From: Michael Eastham <Michael.Eastham@arun.gov.uk>
Sent: 13 May 2021 15:51
To: Planning.Responses <Planning.Responses@arun.gov.uk>
Subject: FW: Ford Lane Yapton - Y/54/21/DOC - CONDITION 11 - Drainage
Importance: High

ADC Drainage Engineers are raising **no objection** to **Condition 11** of discharge of condition application **Y/54/21/DOC**.

Drawing No: 18-3441/09

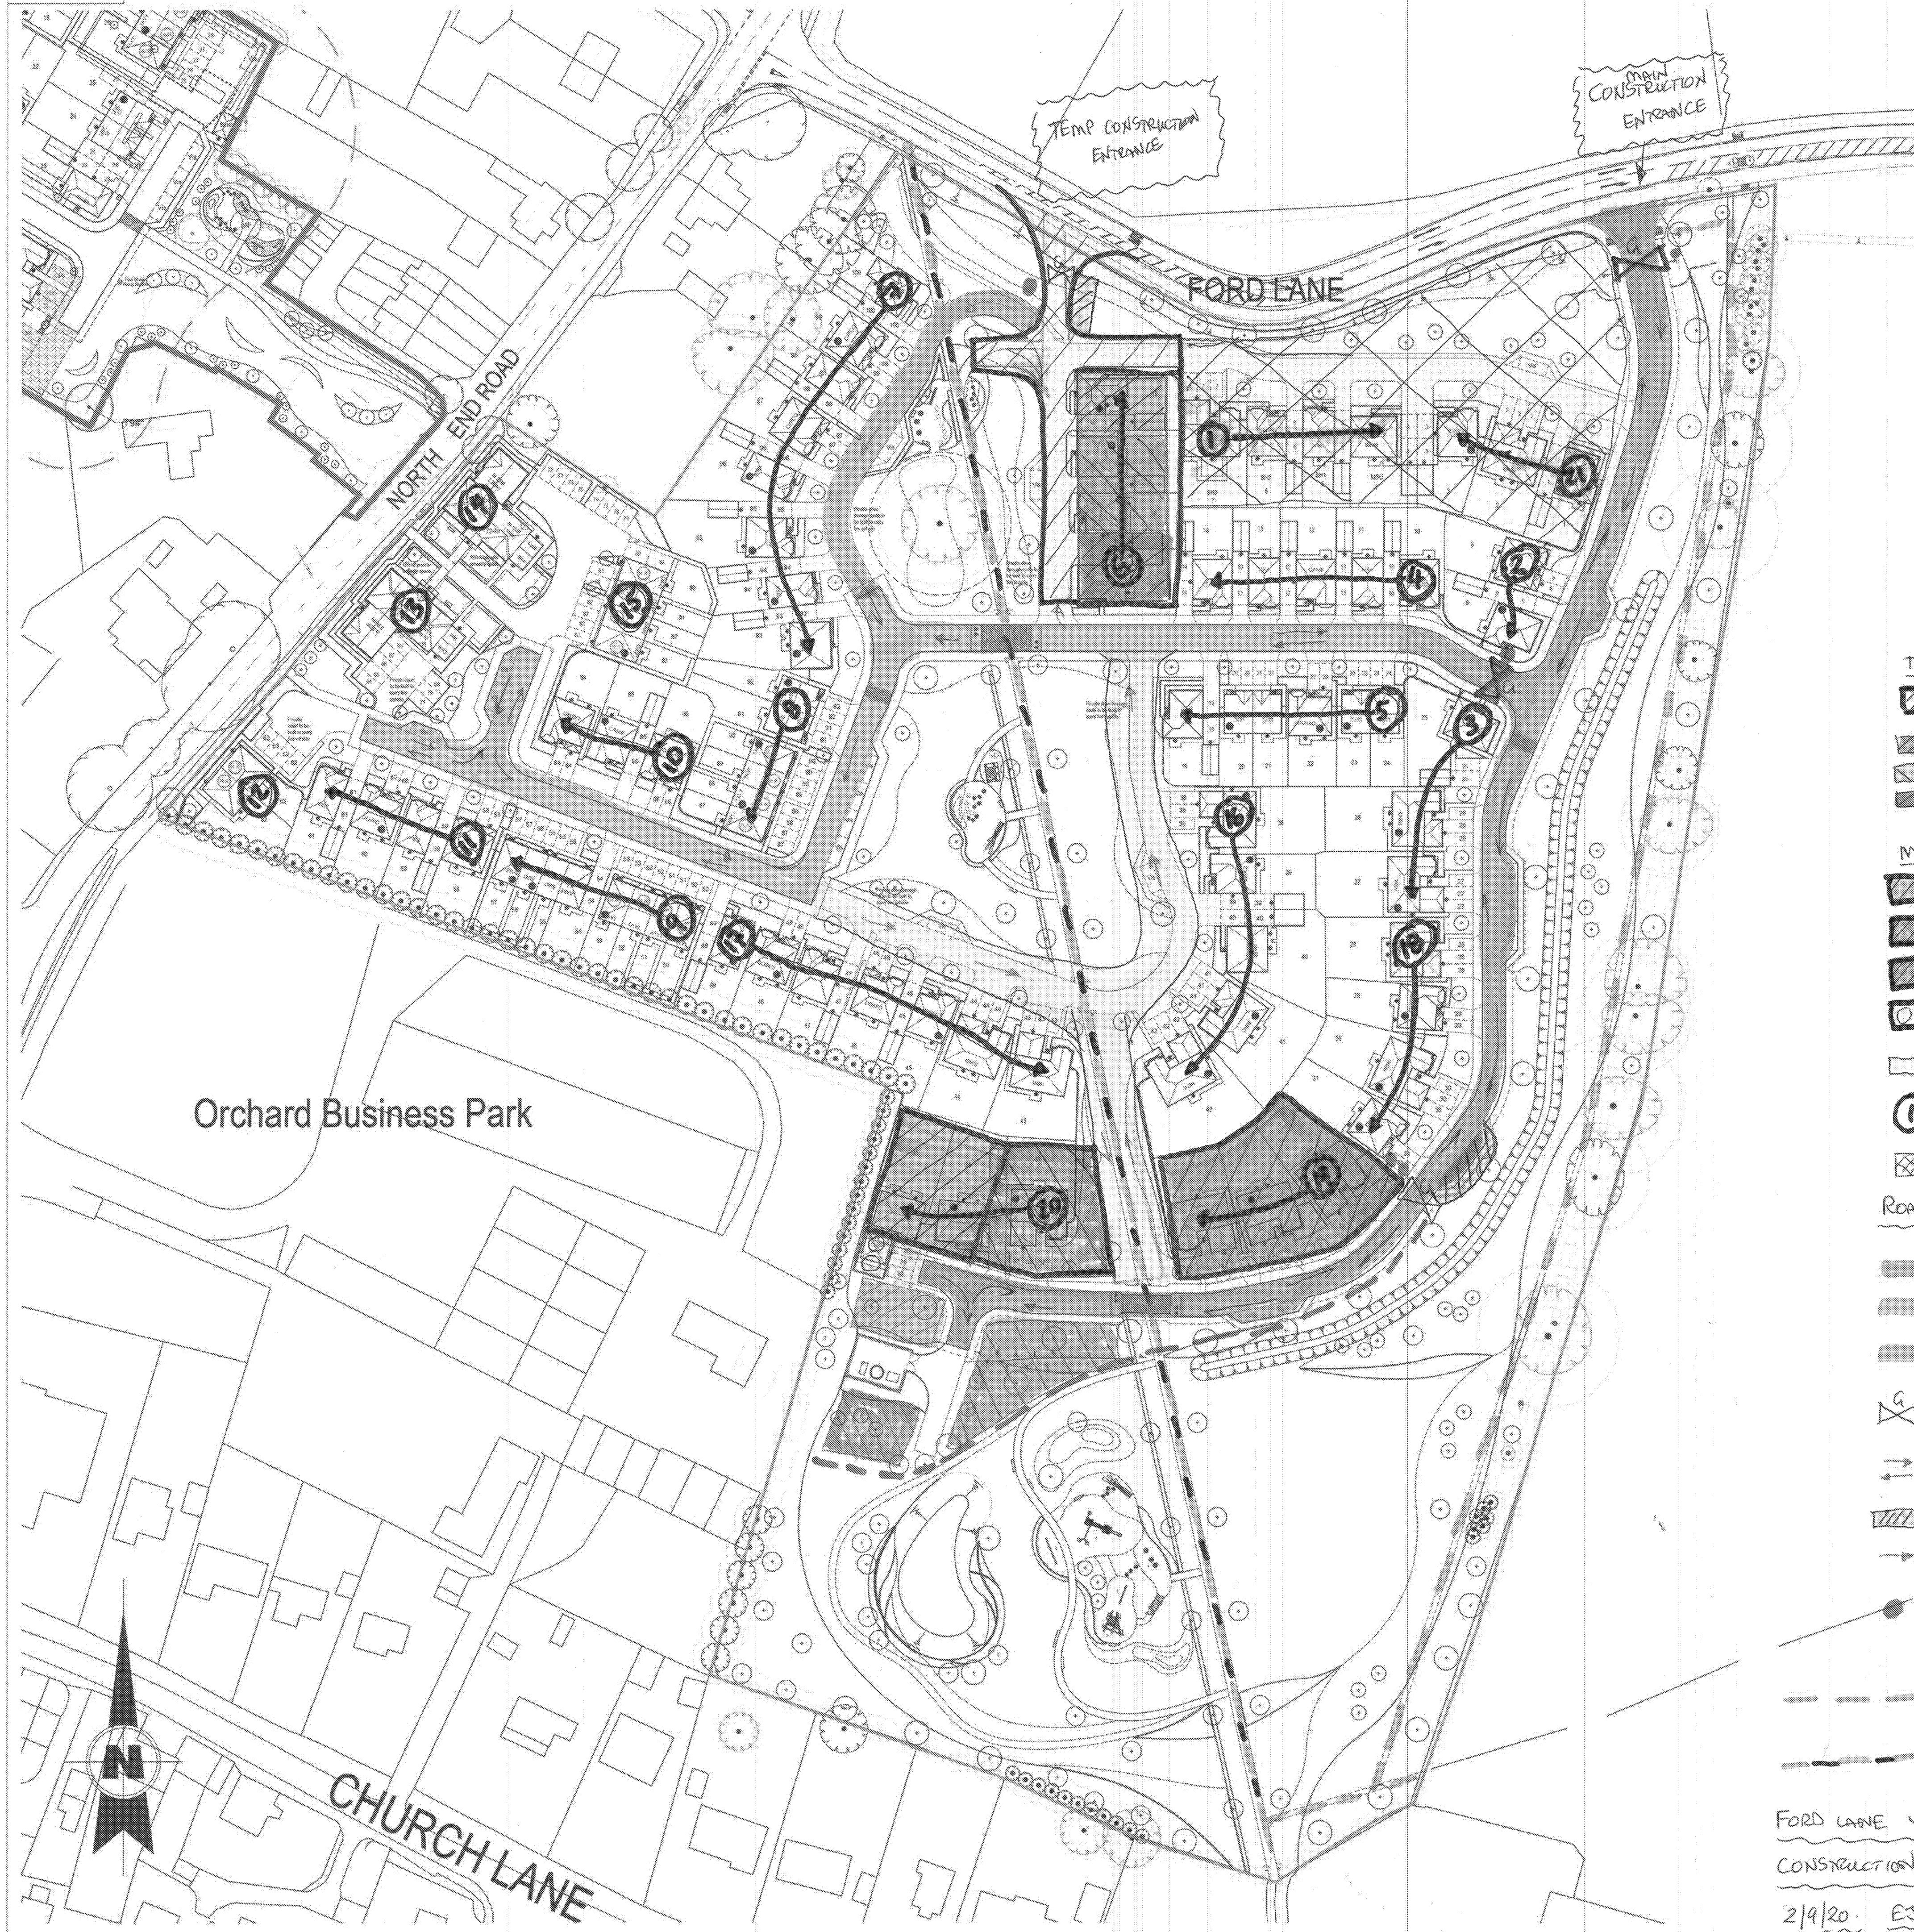
It is a bit difficult to discern, in black and white, the mark up of the sub-areas (as per the first three points) but as far as I can see, I believe this has been done. It would be handy to have a colour copy of the drawings though – I'm not sure if it has been supplied in B/W or it is our system that has saved it in that manner. It would be useful to have those particular drawing supplied separately in colour for later reference.

Thank you for providing me with a colour version. This is much easier to read and enables me to say that I believe the first three points have been met.
